Recommendation Report for Planning Permission for Works or Extension to a Dwelling

REF NO: M/12/22/HH

LOCATION: 9 Sunnymead Close
Middleton-on-sea
PO22 6LS

PROPOSAL: Erection of single storey rear extension.

DRAWING
**PROPOSED
PLANS**
DRAWING No
381/04
REVISION
SCALE 1:100
DATE JAN 2022
DRAWN LA
CHECKED

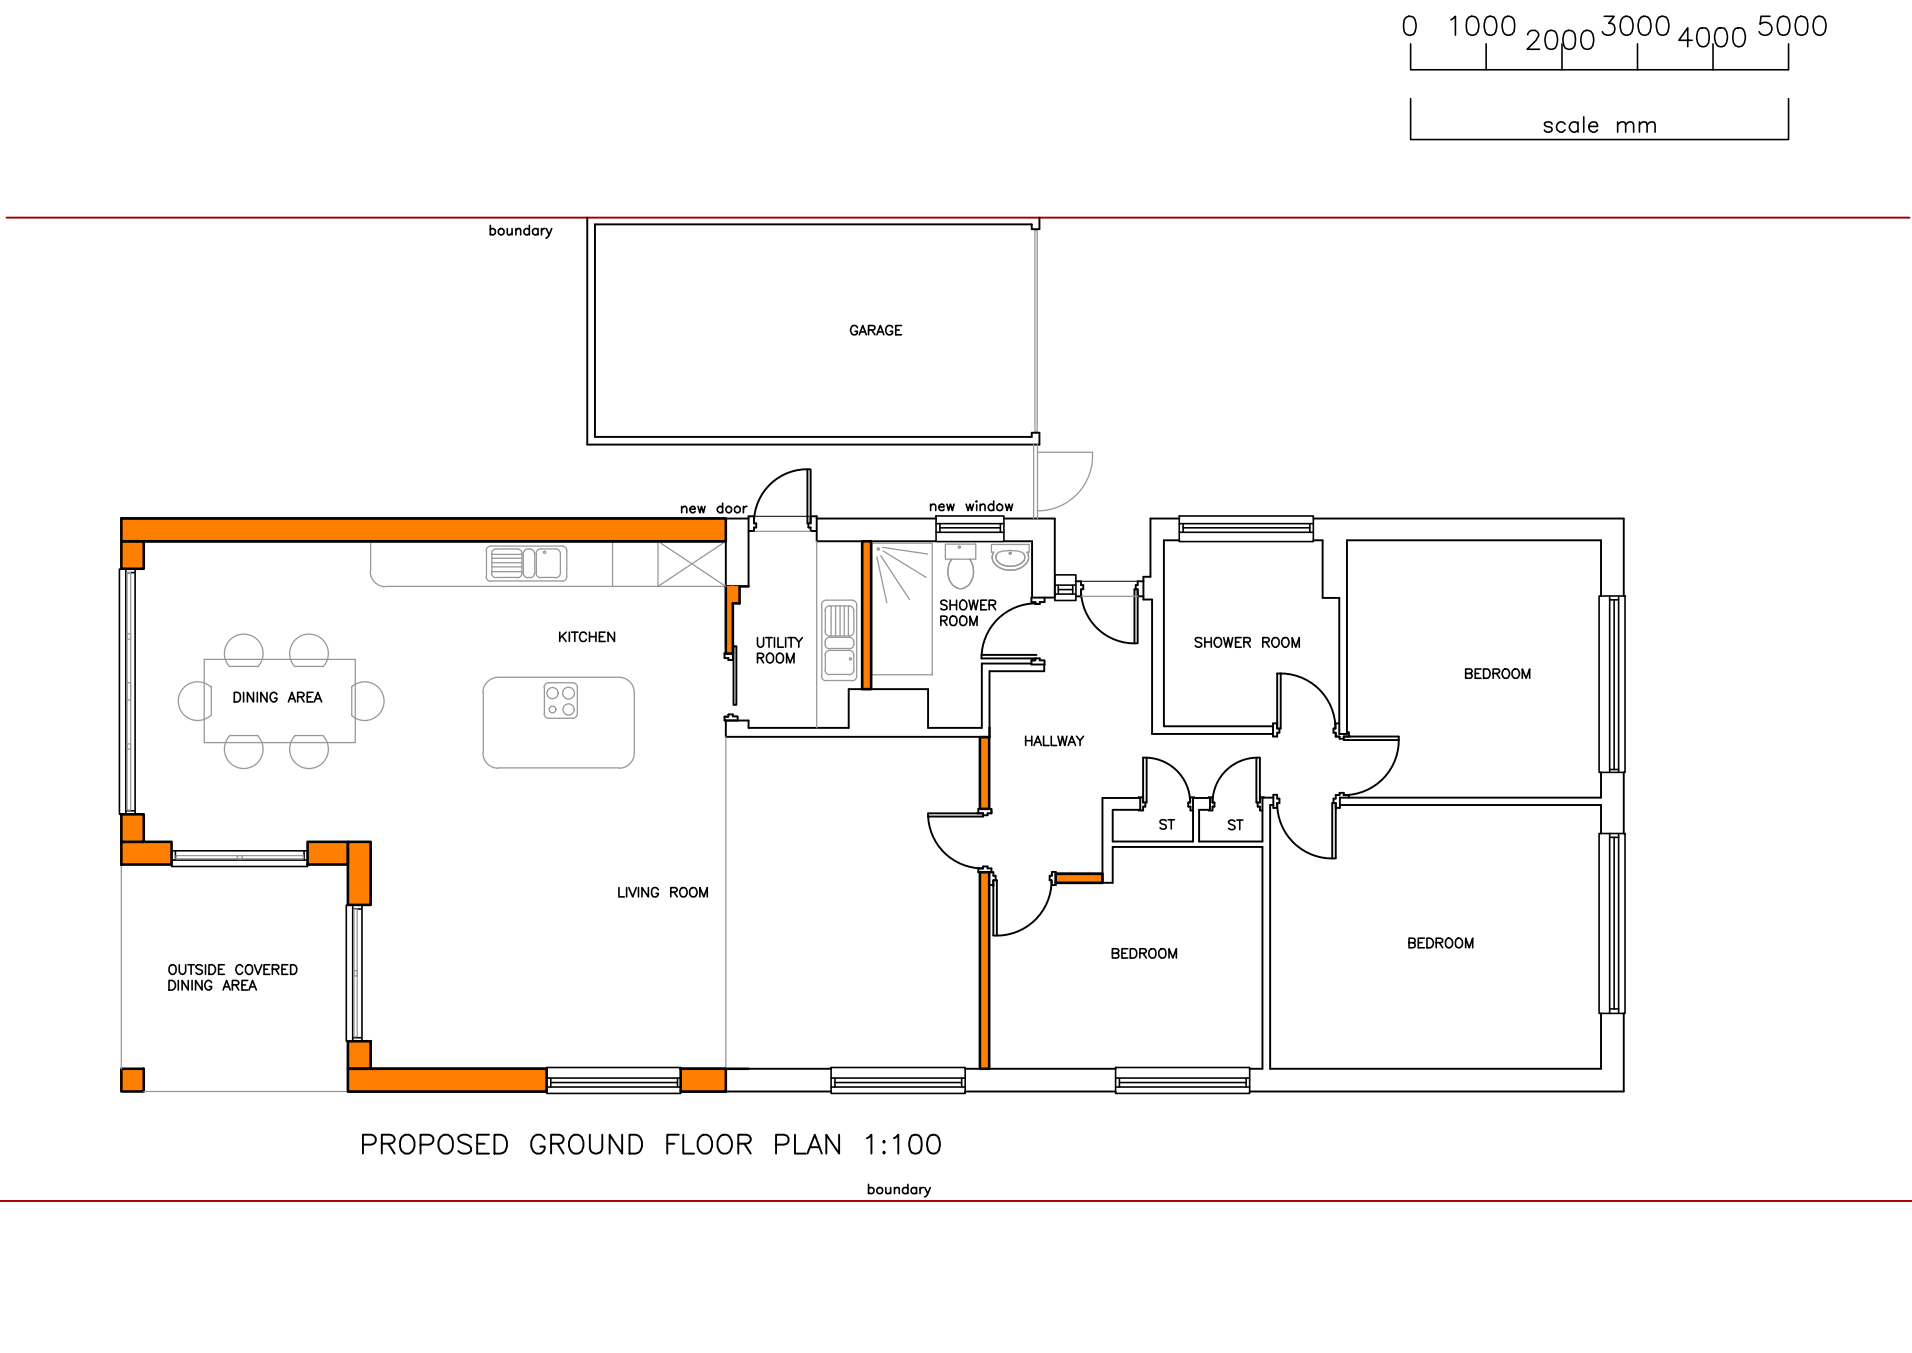
DESCRIPTION OF APPLICATION This application seeks to erect a single storey rear extension that projects approx. 8m to the rear of the property, is approx. 7.6m in width and reaches a height of approx. 5.3m with eaves at approx. 2.5m.

The applicant's architect states on the flood mitigation statement that the addition to the floor print will have minimum impact and that they intend to utilise the existing surface water drainage arrangement. We disagree with this statement. We will strongly oppose any connection of surface water to the foul sewer and would expect the surface water drainage for the new extension to meet current requirements.

- 3 Development shall not commence, other than works of site survey and investigation, until full details of the proposed surface water drainage scheme have been submitted to and approved in writing by the Local Planning Authority. The design should follow the hierarchy of preference for different types of surface water drainage disposal systems as set out in Approved Document H of the Building Regulations, and the recommendations of the SuDS Manual produced by CIRIA. Winter groundwater monitoring to establish highest annual ground water levels and winter Percolation testing to BRE 365, or similar approved, will be required to support the design of any Infiltration drainage. No building / No part of the extended building shall be occupied until the complete surface water drainage system serving the property has been implemented in accordance with the agreed details and the details so agreed shall be maintained in good working order in perpetuity.

DRAWING  
**PROPOSED  
ELEVATIONS**  
DRAWING No  
**381/05**  
REVISION  
SCALE 1:100  
DATE JAN 2022  
DRAWN LA  
CHECKED

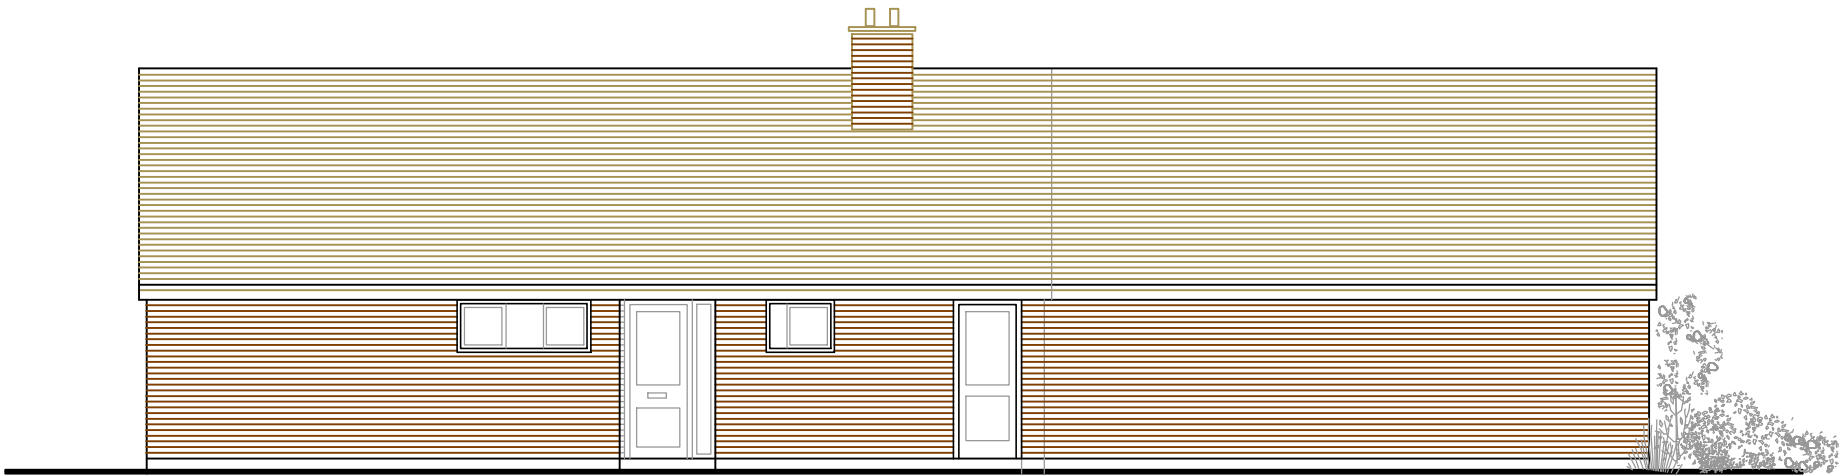
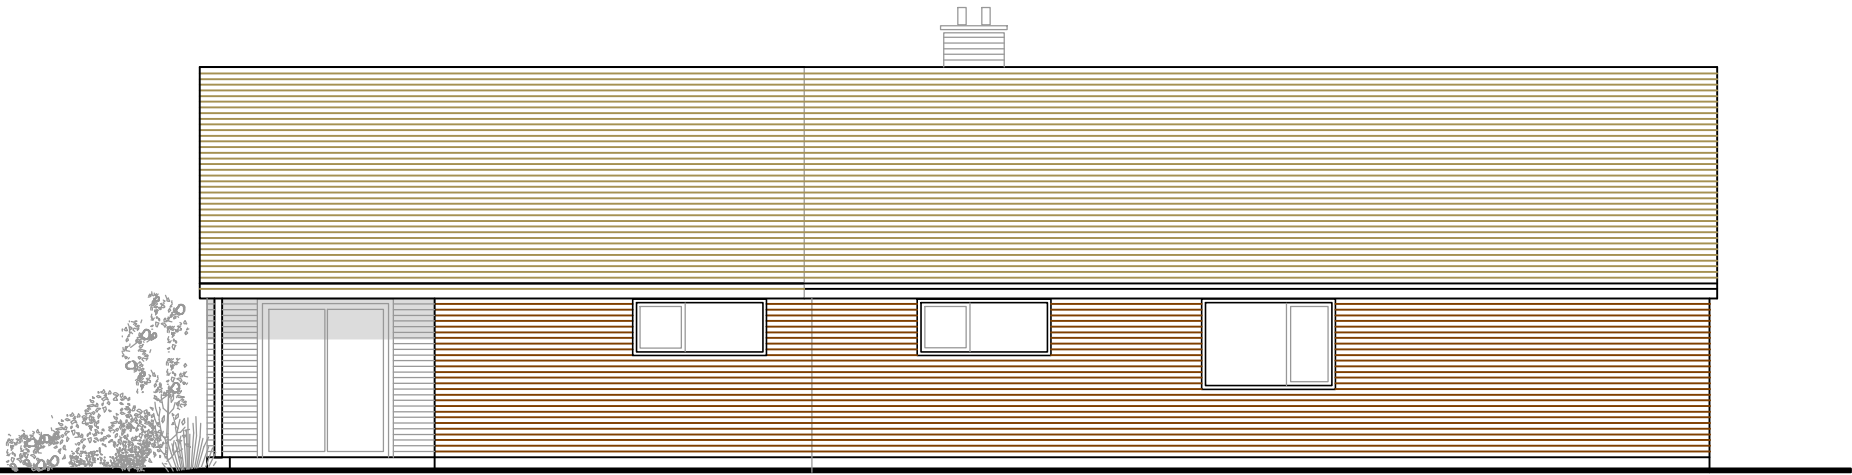
The proposed rear extension is to project approx. 8m to the rear of the property, it is approx. 7.6m in width and reaches a height of approx. 5.3m with eaves at approx. 2.5m. The scale of this proposal is large relative to the host dwelling and as such not visually subservient. Section M of the Arun Design Guide states that extensions more than a 50% floorspace increase are unlikely to be considered acceptable and the Middleton Village Design Statement says extensions should be in keeping with the scale of existing dwellings. The overall depth of the proposal is approx. 20m which is comparable to other long dwellings within the locality such as No. 3 Sunnymead Close at approx. 18m. There is also, substantial retention of rear amenity space at 32m and it is separated from the North and South (side) site boundaries by 3.5m and 1.5m respectively. The proposal is contrary to Section M of the Arun Design Guide and the Middleton Village Design Statement. However, given the substantial curtilage of the proposal, comparable length to nearby properties, well integrated design and that it gives no rise to adverse impacts on neighbouring amenity (discussed later in the report), the scale is considered acceptable. In all, this is a large-scale full extension of the rear of the property and despite not being subservient to the host dwelling, it is of an acceptable scale within its curtilage.

The proposal is visually integrated with the host dwelling, matching the roof form, meeting both existing

side elevations and using matching materials to those found on the host dwelling. The proposal is in character with its host dwelling and locality. The proposal is not visible from the front and as such, will have no visual impact on the street scene.

The proposal would result in the rear elevation exceeding the depth of the neighbour dwelling to the North (No. 11 Sunnymead Close) but not that of the neighbour dwelling to the South (No. 7 Sunnymead Close). The proposal is single storey and features a pitched roof design with eaves at approx. 2.5m. Section M of the Arun Design Guide illustrates the 45 degree rule regarding light accessibility. The height of the proposal, roof design and separation from side site boundaries means there is no intersection of the 45 light accessibility lines and as such, there will be no adverse impacts by way of overshadowing on any neighbour dwellings.

The proposal does not exceed the depth of No. 7 Sunnymead Close and is of single storey. It does however, exceed the depth of No. 11 Sunnymead Close by approx. 4.2m. Section M of the Arun Design Guide illustrates the 60 degree rule regarding the sight lines from rear viewpoints of neighbouring dwellings. The proposal does not intersect any 60 degree sightlines from either No. 7 or No. 11 Sunnymead Close and as such, has no adverse impact by way of overbearing.

There are 6 No. rear facing glass windows/doors included in the proposal. These look out to the rear of the property and give no rise to any adverse impacts by way of overlooking.

There are also to be 3 no. south facing glass windows/doors at the end of the rear extension. These are ground floor viewpoints that look out to the site boundary which consists of a boundary fence and as such, do not give rise to any adverse impacts by way of overlooking.
